Appeal Decision

Appeal Ref: APP/C3810/D/10/2129809

9 Sark Gardens, Ferring, Worthing, West Sussex BN12 5QB

2. For the avoidance of doubt, the plans that I have considered in relation to this appeal are those entitled *'Proposals 10 B'* (incorporating Revisions A and B) and *'Proposals 11 C'* (incorporating Revisions A, B and C). Both drawings are dated December 2009 with the final revisions thereto dated 3 March 2010.

**1st FLOOR PLAN**

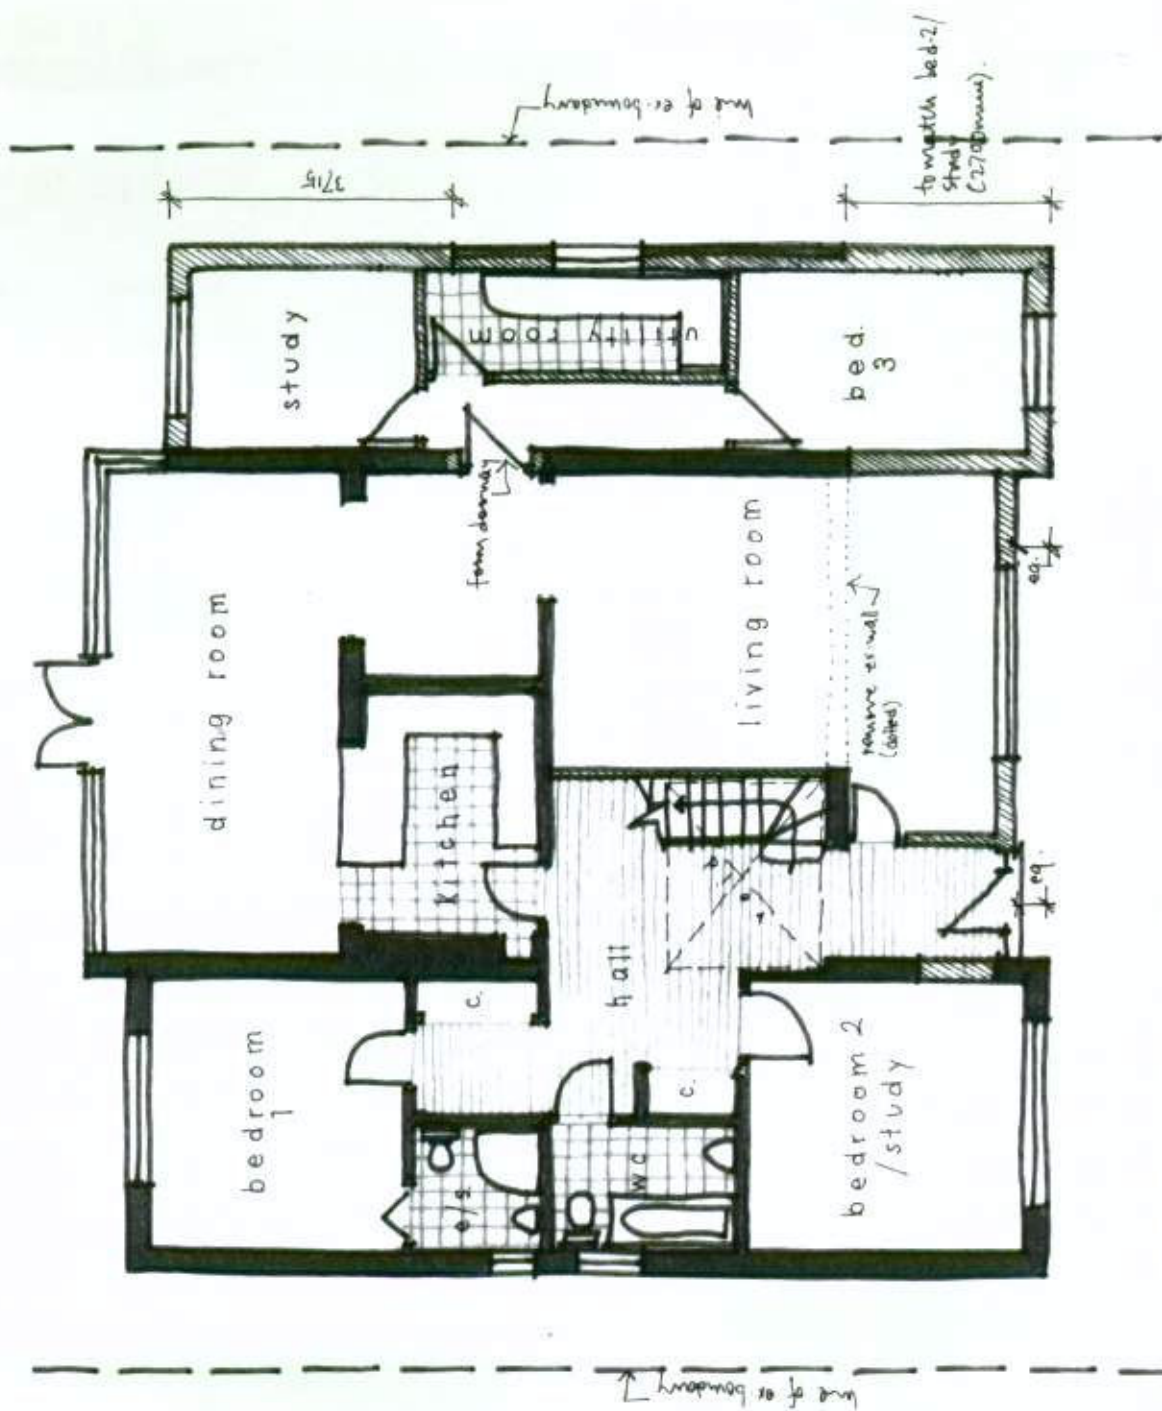
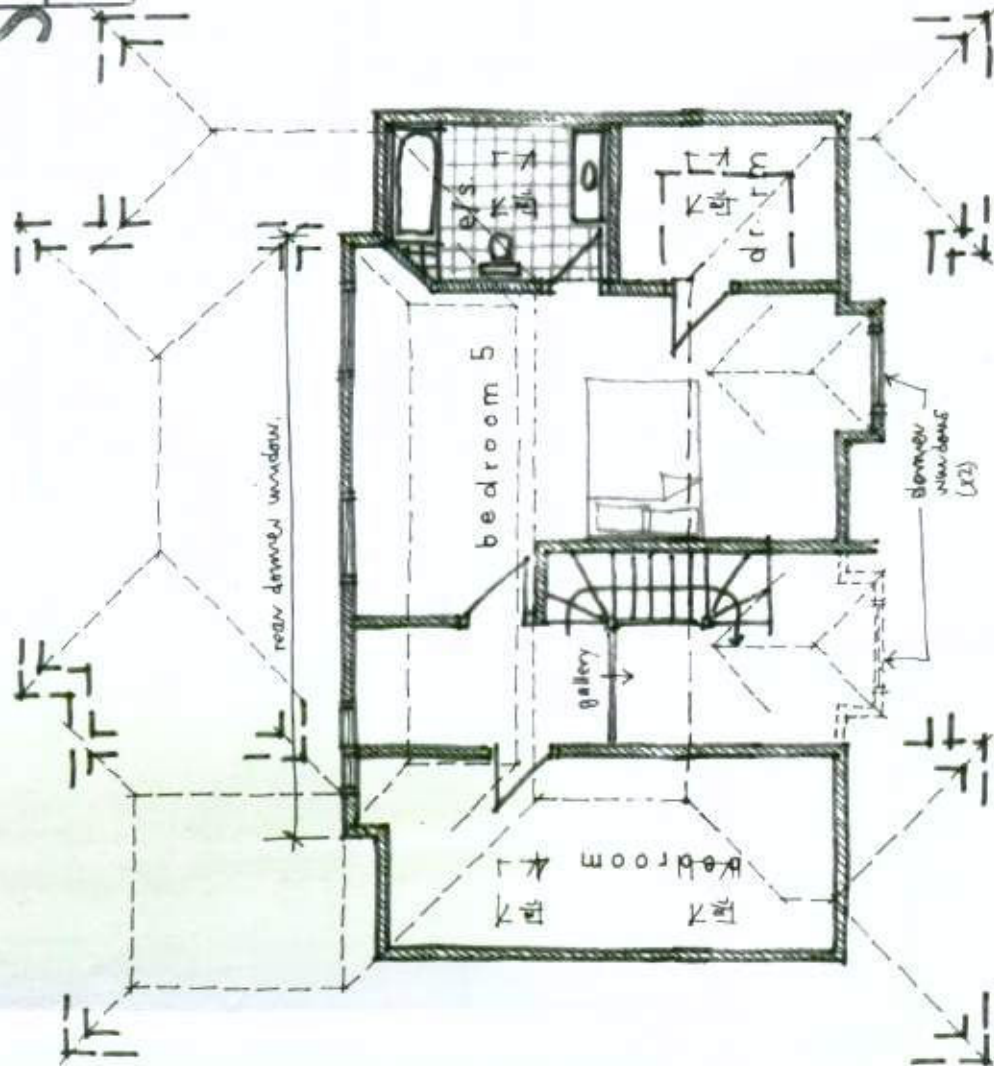
7. On the second main issue, three dormer windows are proposed in the rear elevation of the property to serve habitable rooms. Overlooking towards the adjoining properties in Tamarisk Way and Beehive Close would be inevitable. Particularly, the garden and windows in the rear elevation of No 6 Tamarisk Way would be about 20-metres away and uninterrupted views into this property from the first floor of the extended property would be possible.

PROPOSED ELEVATIONS 1:100

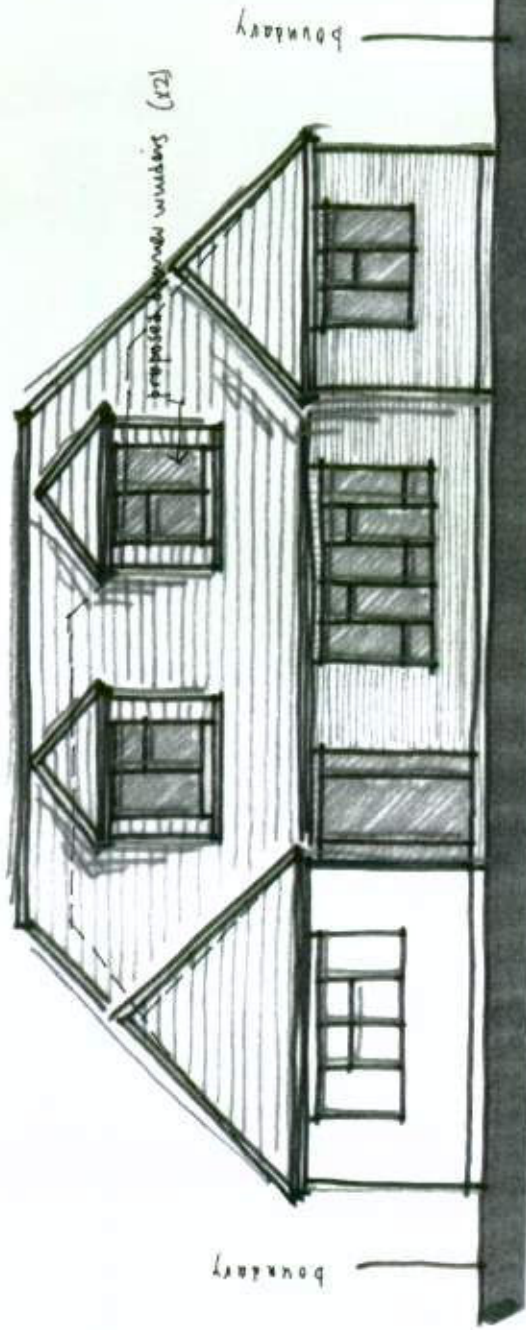
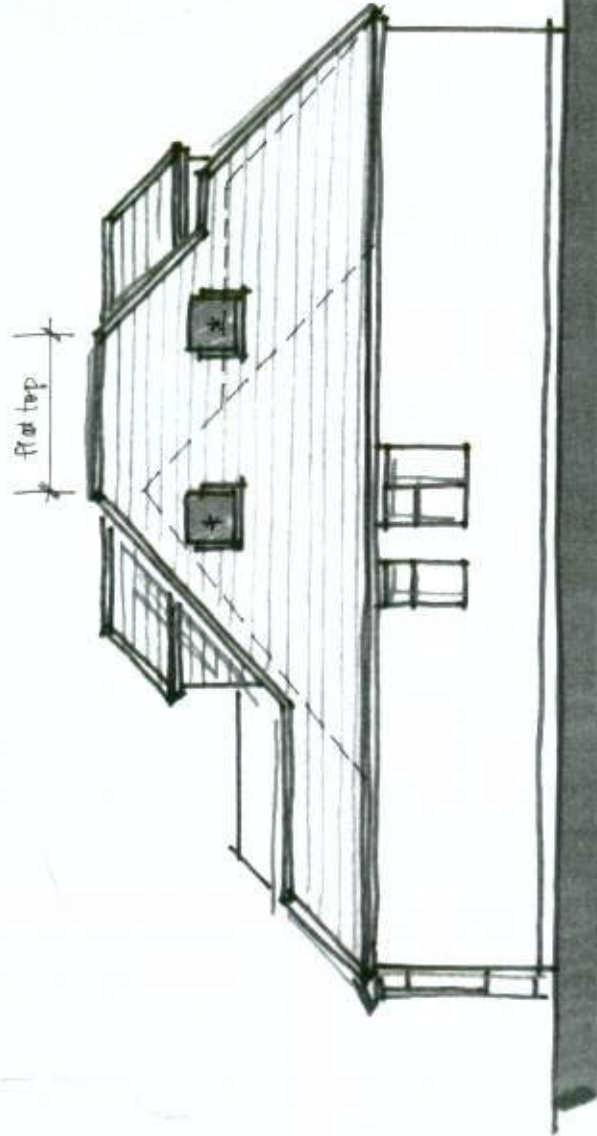
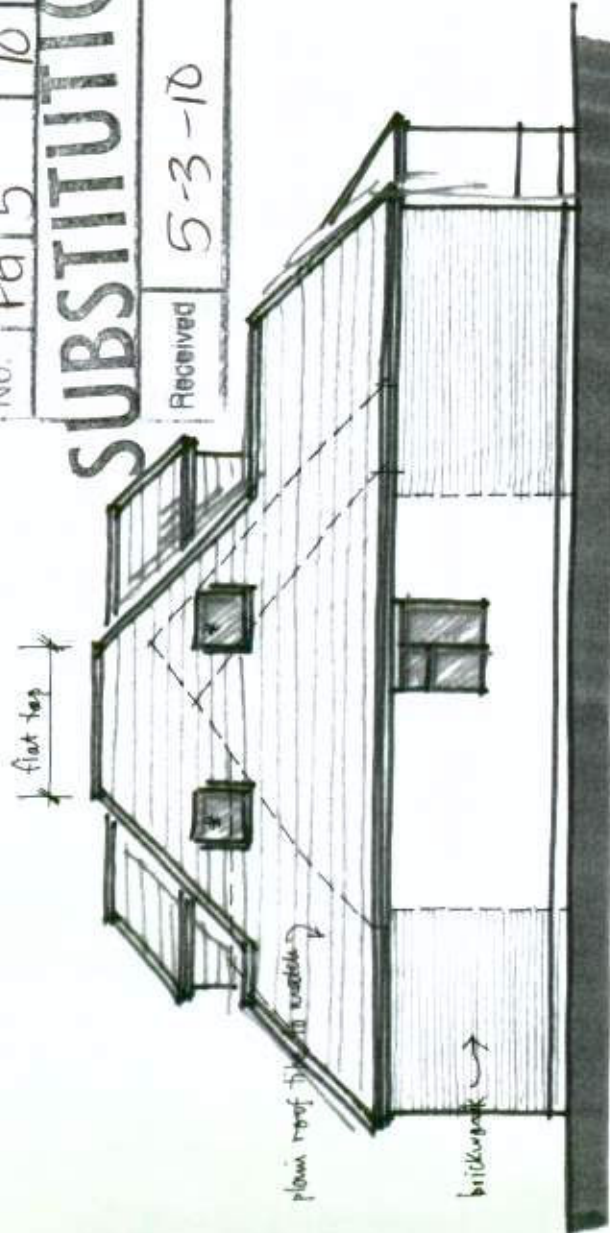
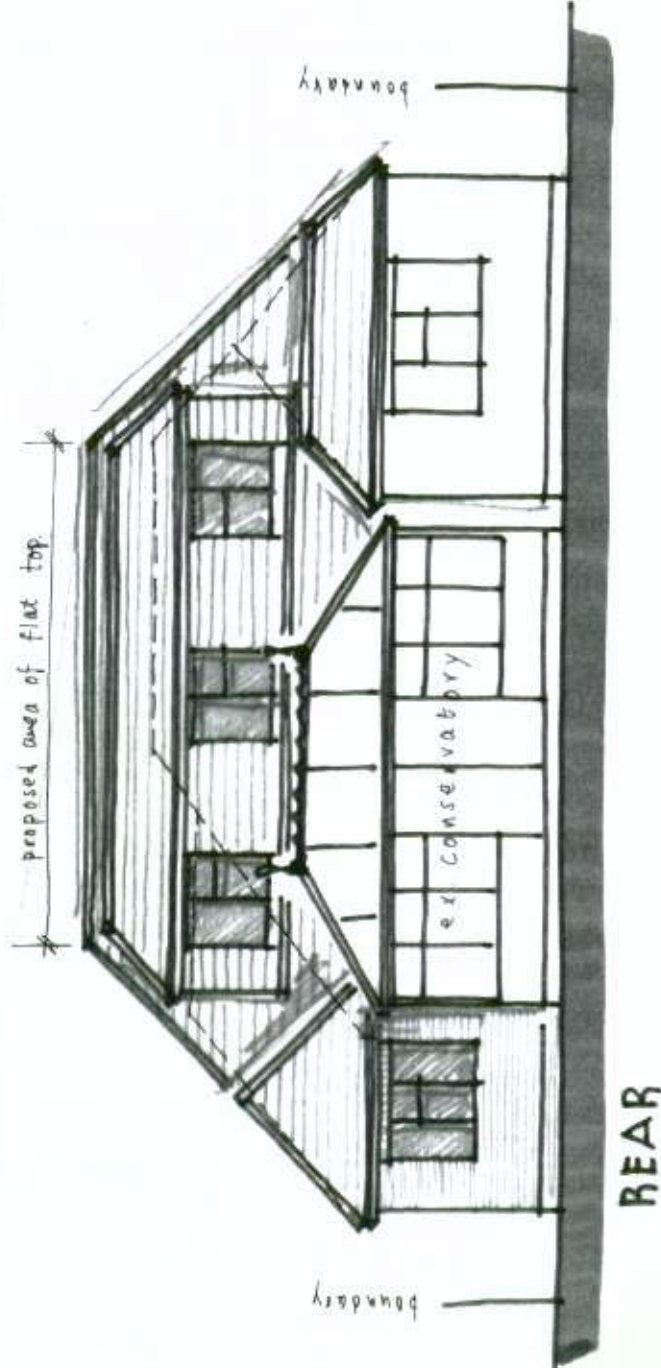
6. The proposed development would involve an increase in the height of the roof and the formation of two large dormer windows in the front elevation of the building. This would radically alter the appearance of the dwelling and would introduce a discordant and incongruous feature into the streetscene facing towards a group of modest, detached bungalows. The building would take on much of the character of a substantial, two-storey house when viewed from Sark Gardens. As such, in my view, and in terms of the first main issue, the development would be in conflict with Saved Policies GEN7 and DEV19 of the Arun District Local Plan (2003). For these reasons the proposals are unacceptable on this issue.
